Re: 2025/91554 – Proposed Non-Material amendment to 2024/91260 and 2021/92801

Further the submission of our application under the above reference please find accompanying this letter a revised layout, ref. 122-PL-01-A-A, which, in addition to those changes originally included, now includes the revised arrangement for the access road to serve the adjacent attenuation pond.

Title: Substation External Works

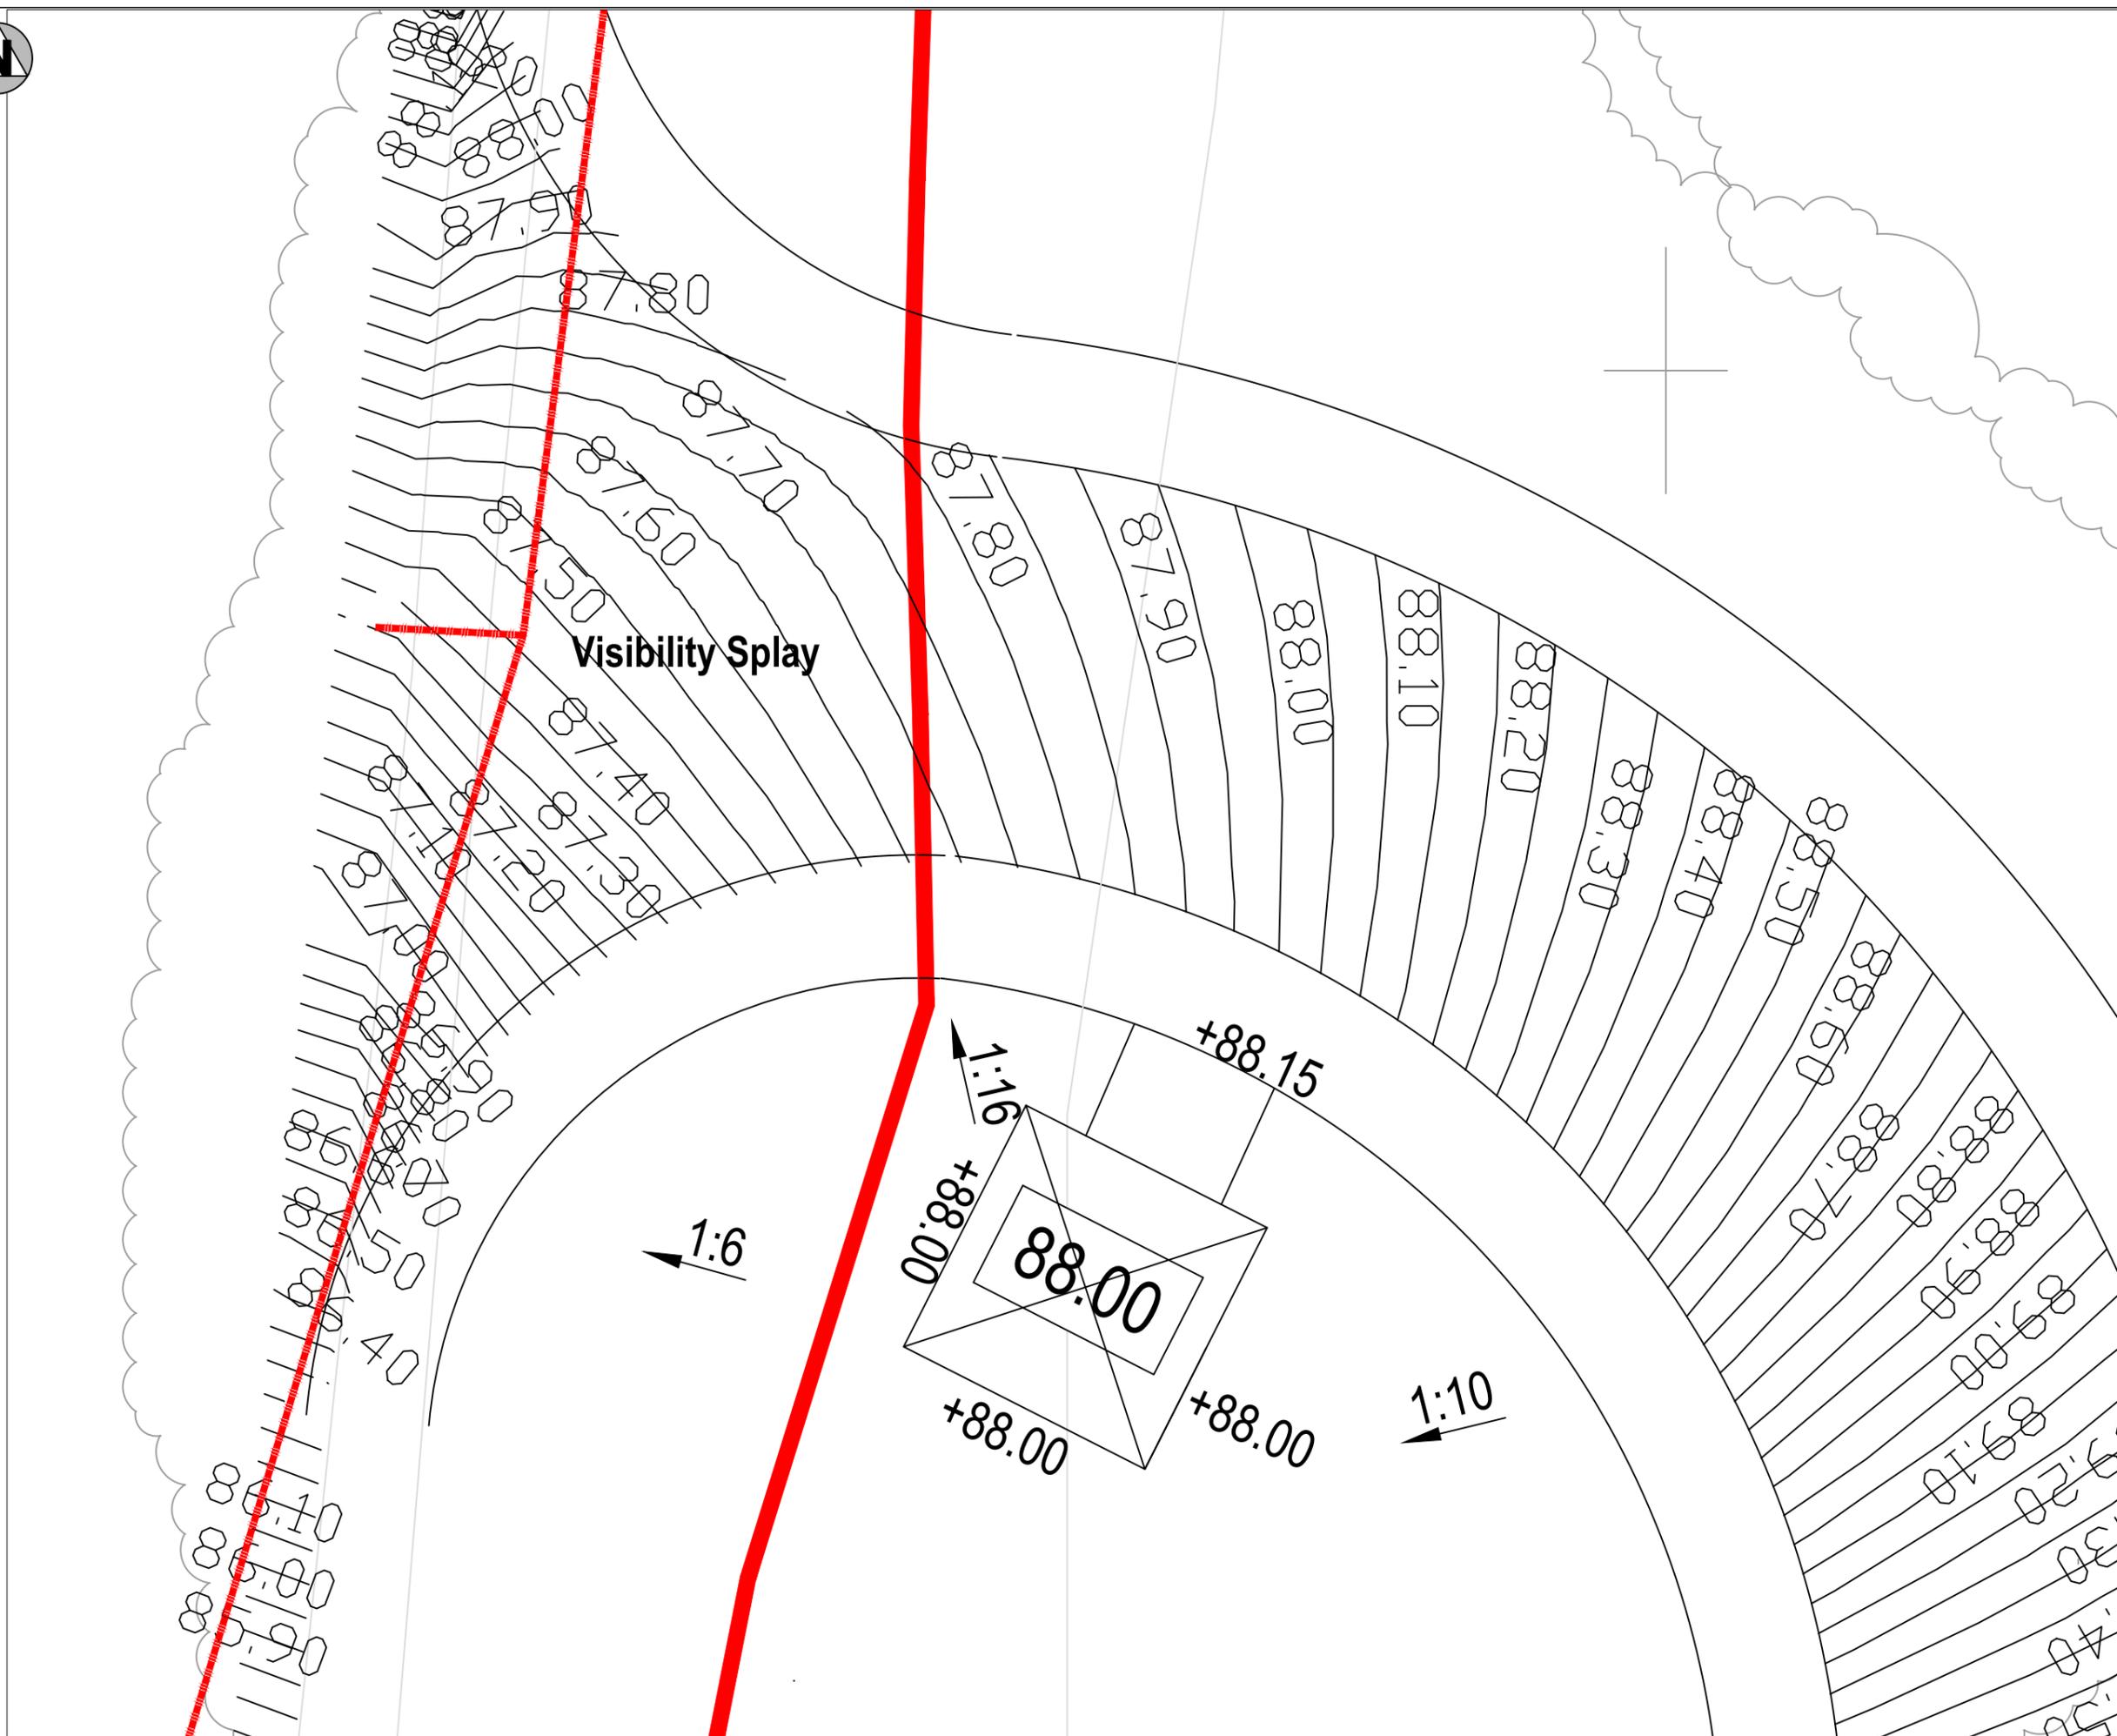
- Affordable Homes plots 197-201 relocated to [new] plots 204-206 inc. and 108-109 inc.
- The proposed electricity sub-station has been relocated to suit the utility connection point and reduce the impact on the inhabited street scene,
